App No: BE/27/20/PL

Address: Land at Salt Box West of Shripney Road Bersted

Proposal: Creation of temporary soil storage bund & haulage route associated with development of adjoining site at Saltbox (resubmission following BE/38/19/PL). This application may affect the character & appearance of the Shripney Conservation Area & is a Departure from the Development Plan.

Soil Stockpile

TOP SOIL RELOCATION  
 SITE PLAN  
 1744-TS-P02-E

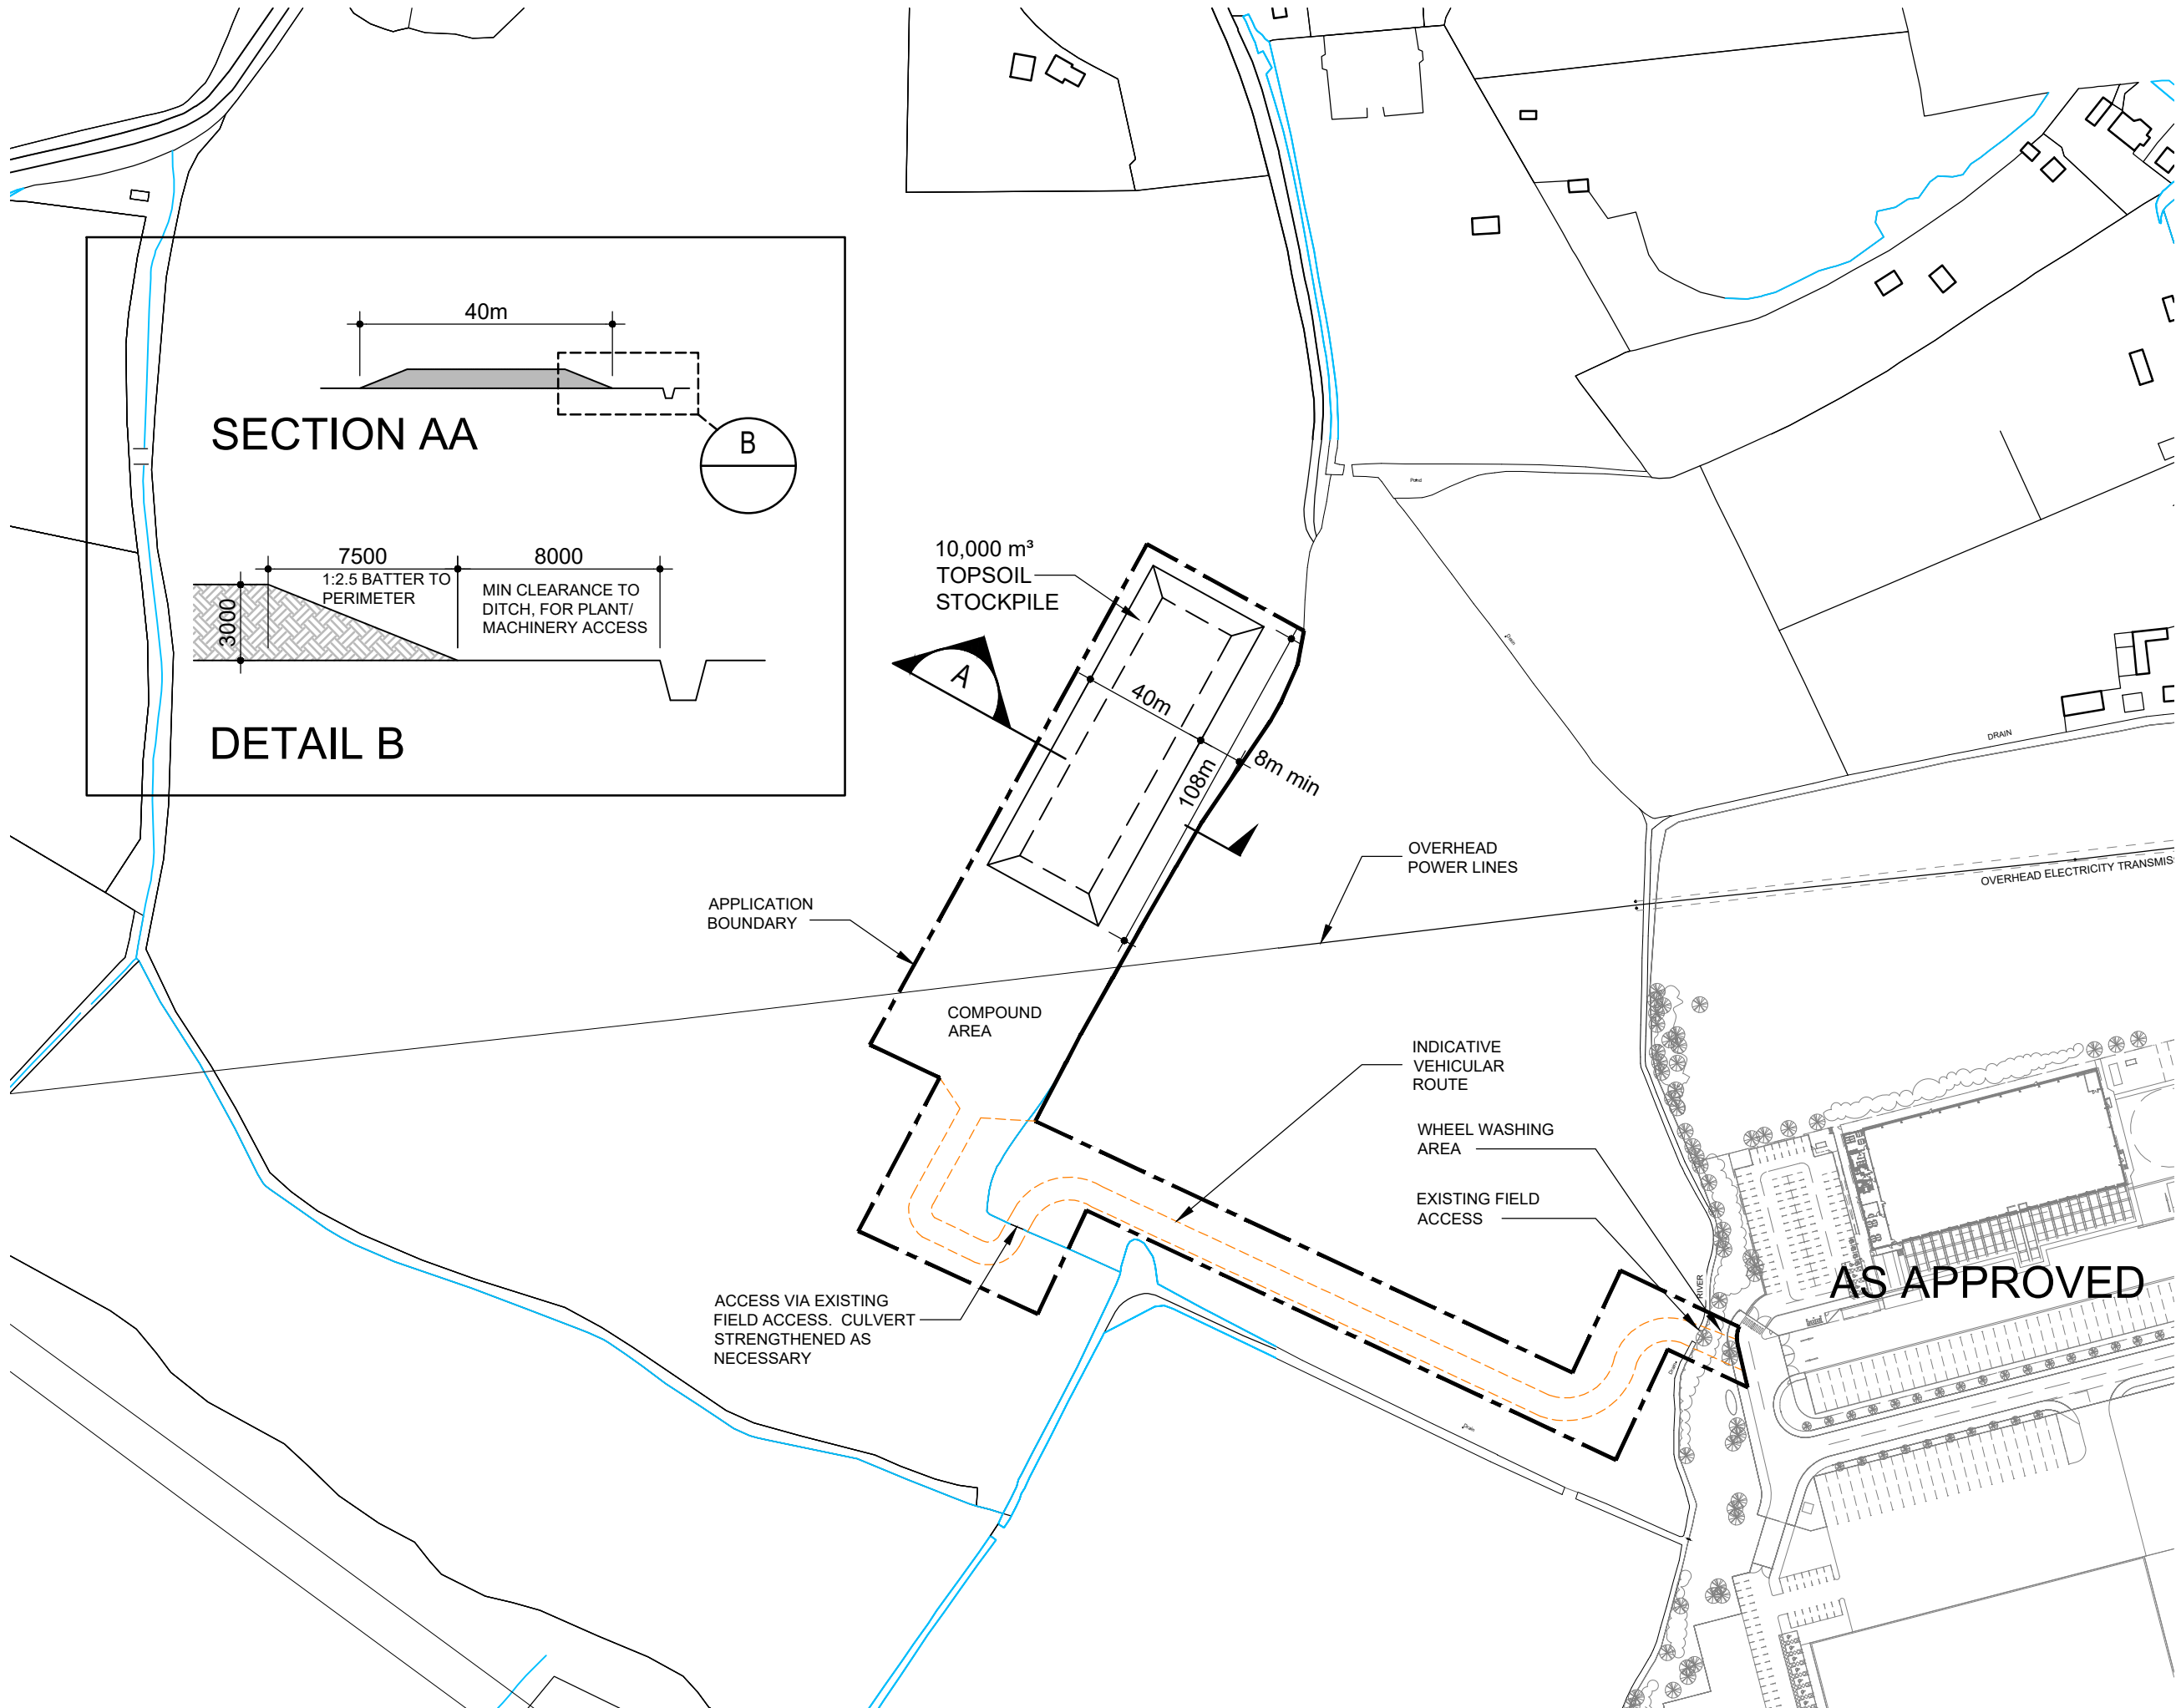
As detailed within the ecological report submitted for the previous application (BE/8/19/PL) an 8m easement / buffer area will need to be included between the stockpile and the southern and eastern field boundaries.

Fencing should be used to protect the boundary features to ensure no works encroach on these areas and should tie in with the construction fencing required for the previous permission.

Works should proceed in a directional manner so the southern extent of the stockpile is created first and retained the longest to provide an additional buffer and screening.
